**Reference:** H22-0353-26  
**Proposal:** Self Build Replacement Dwelling  
**Location:** Magpie Cottage Delgate Bank Weston Spalding  
**Applicant:** Earl Farming

### **Acceptance of Amendment Number 1**

DRAWING No.
123 P02

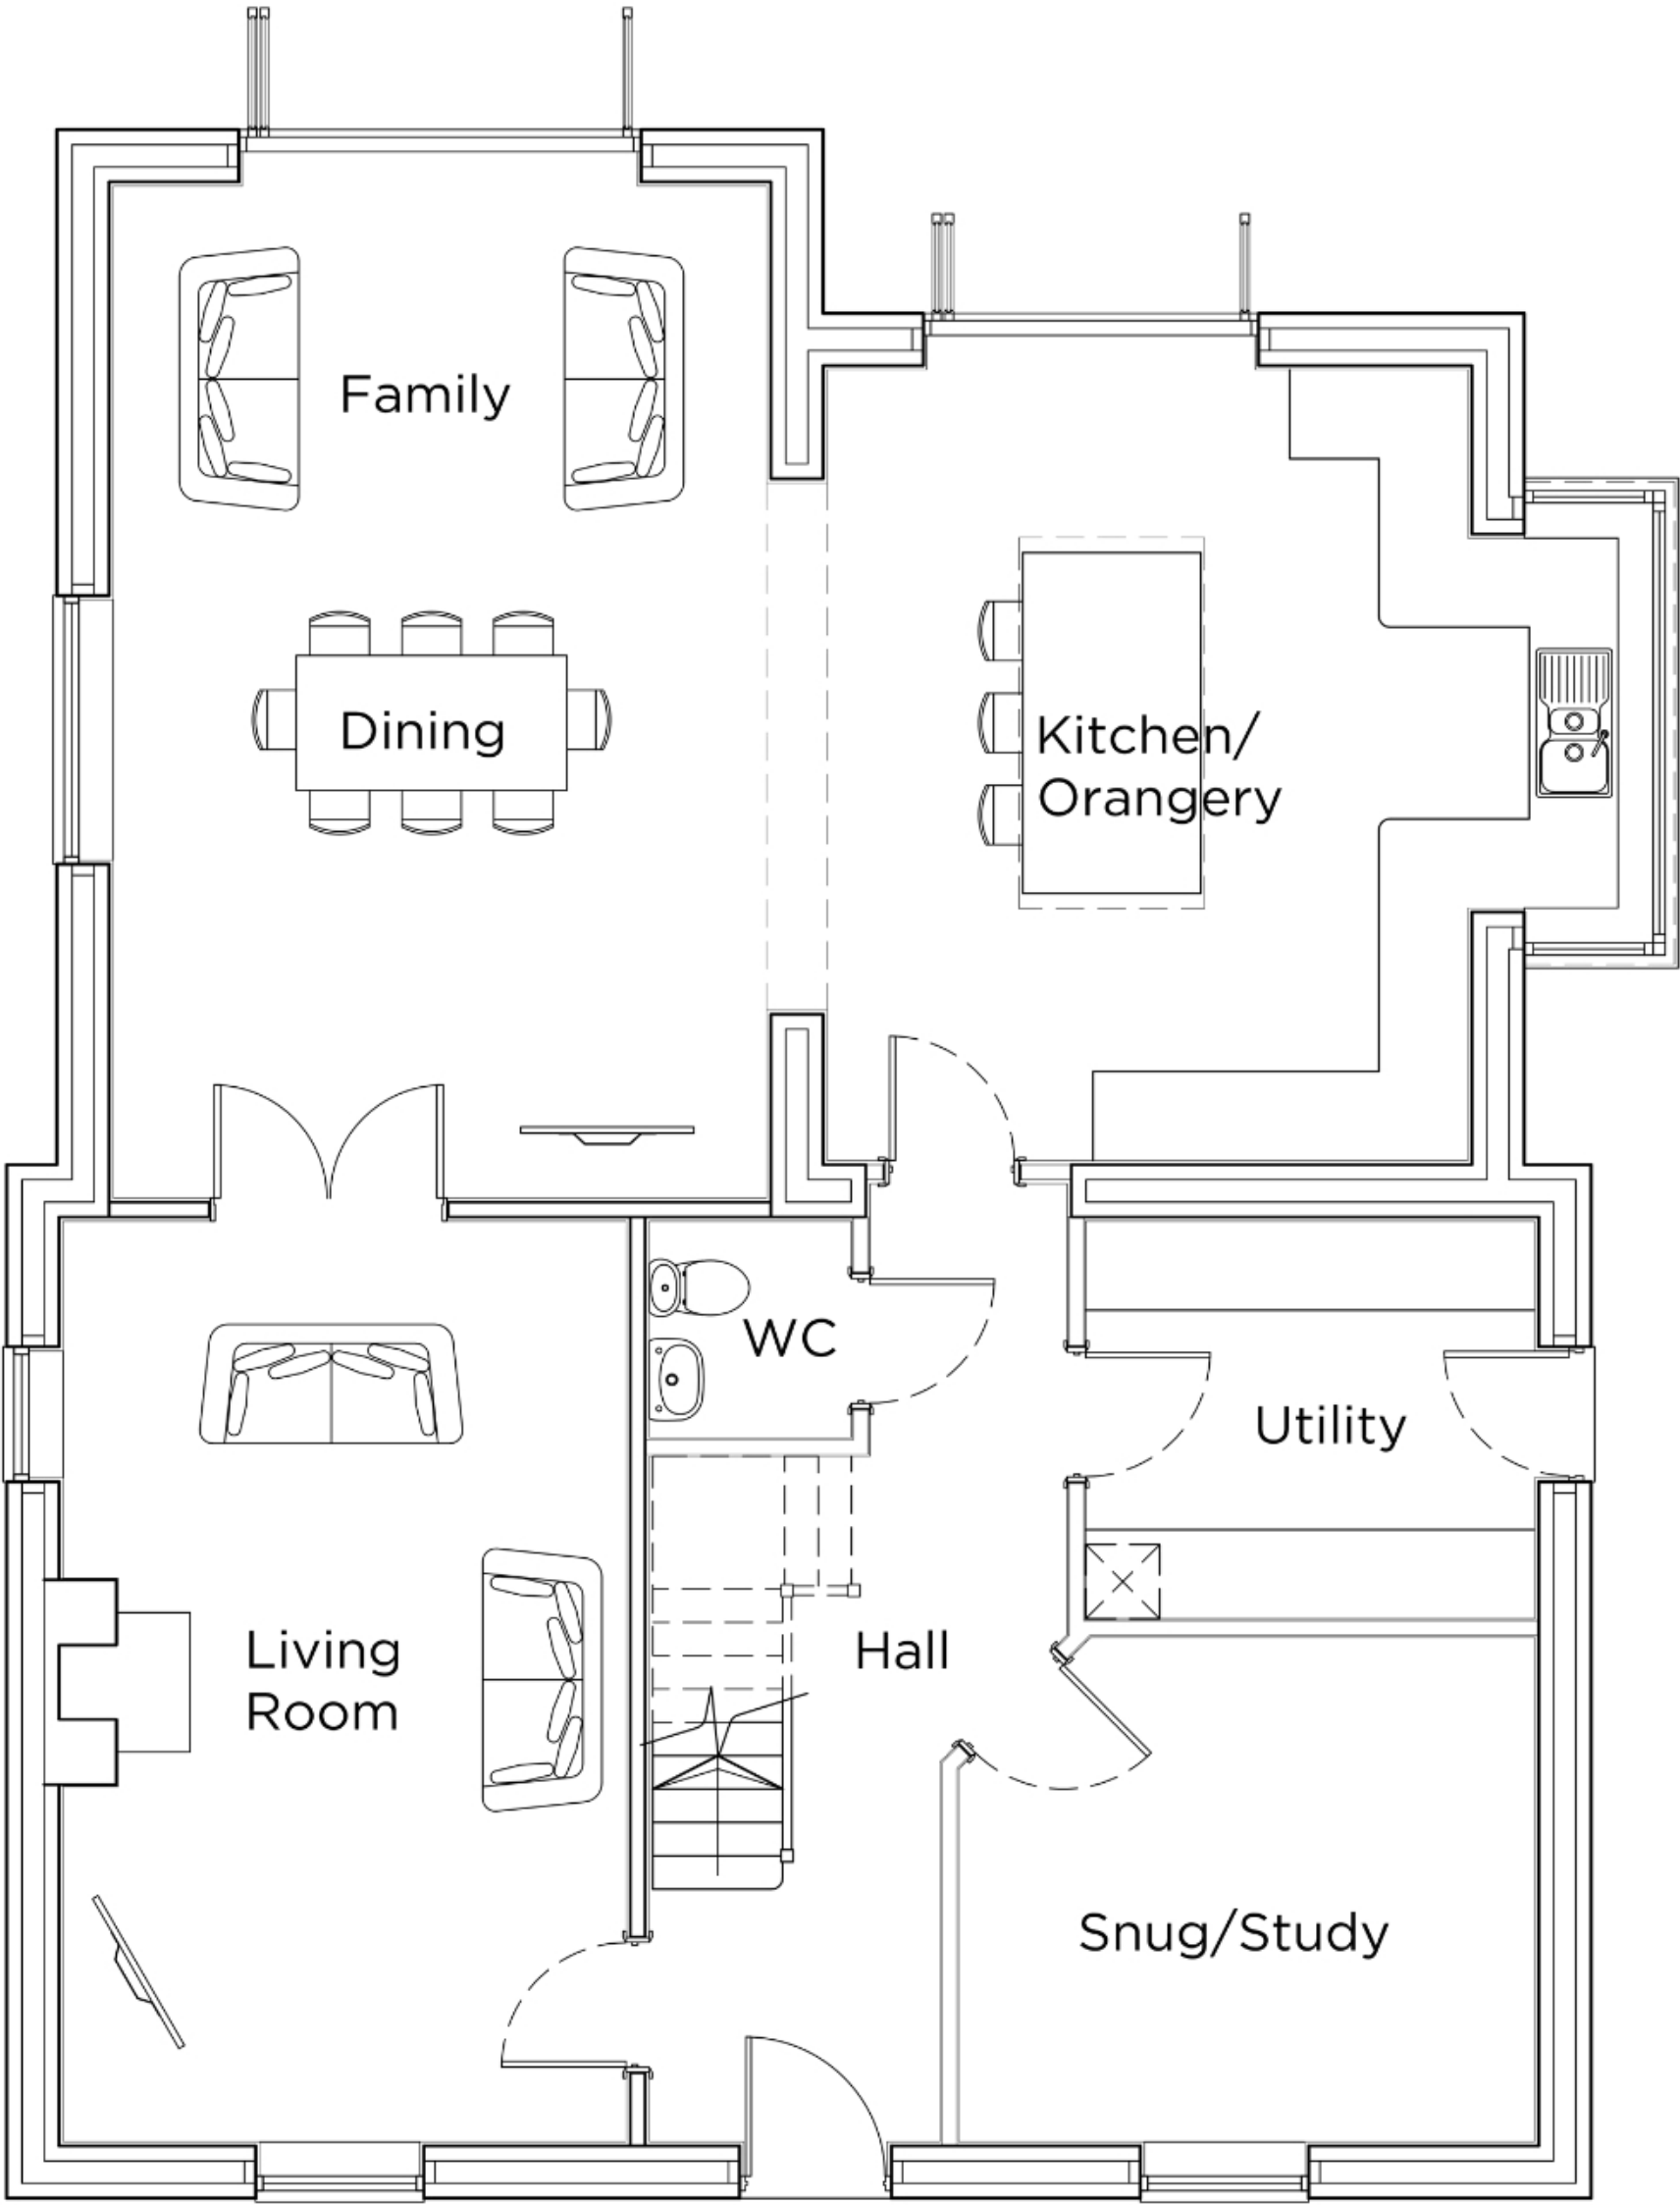
**Entrance porch replaced with arched doorway to match existing. Front fenestration amended. Arched window added to side elevation. Chimneys widened & lowered. Height scale & massing reduced.**
